WEAKLEYS DRIVE (HW9): ALDI WAREHOUSE PROJECT, BERESFIELD (MP 10_0042)

I refer to your letter dated 16 September 2010 (Your reference: MP 10_0042), received on 20 September 2010, regarding the subject project application forwarded to the Roads and Traffic Authority (RTA) for consideration.

Dave Young
Manager, Land Use Development
Hunter Infrastructure Services

8 October 2010

Figure 7: Proposed Road Network

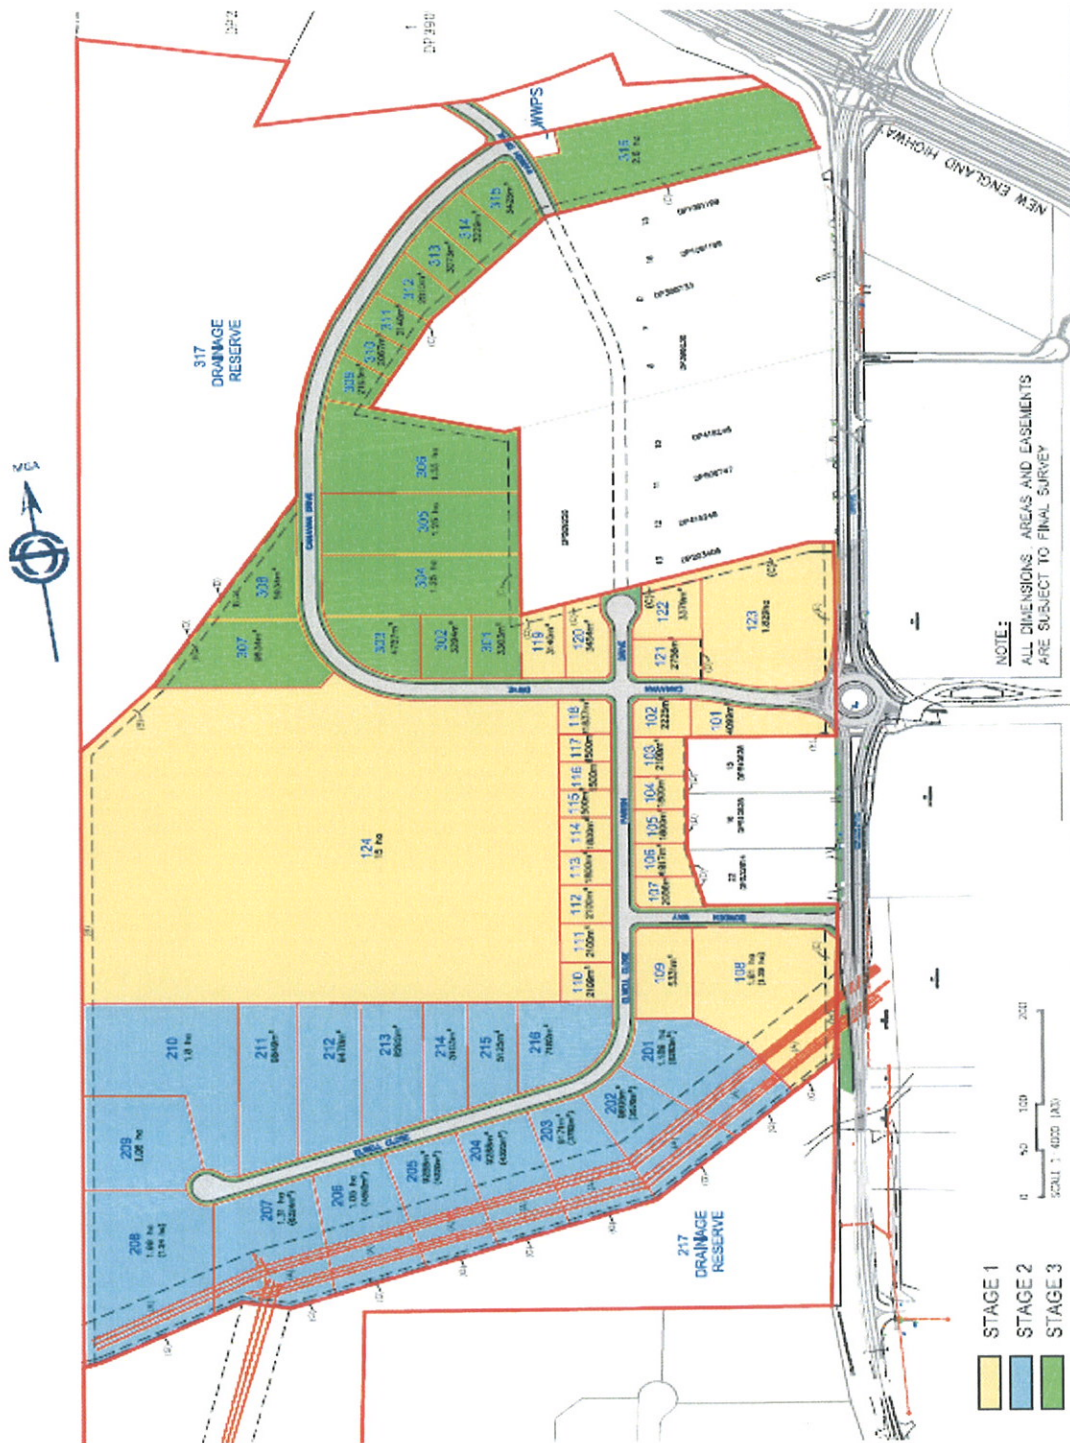
to construct access to this site is the responsibility of the proponent of the Freeway North Business Park, the RTA requires that the intersection of Weakleys Drive and Canavan Drive is completed prior to any works commencing on site for this project.

Comment: The intersection of Weakleys Drive and Canavan Drive shall be constructed as a dual lane circulating roundabout. Two lane approach and departures shall be provided on each leg.

Accordingly, a construction certificate for the subject development should not be granted until practical completion for the proposed roundabout at the intersection of Weakleys Drive and Canavan Drive has been achieved, to the satisfaction of the RTA.
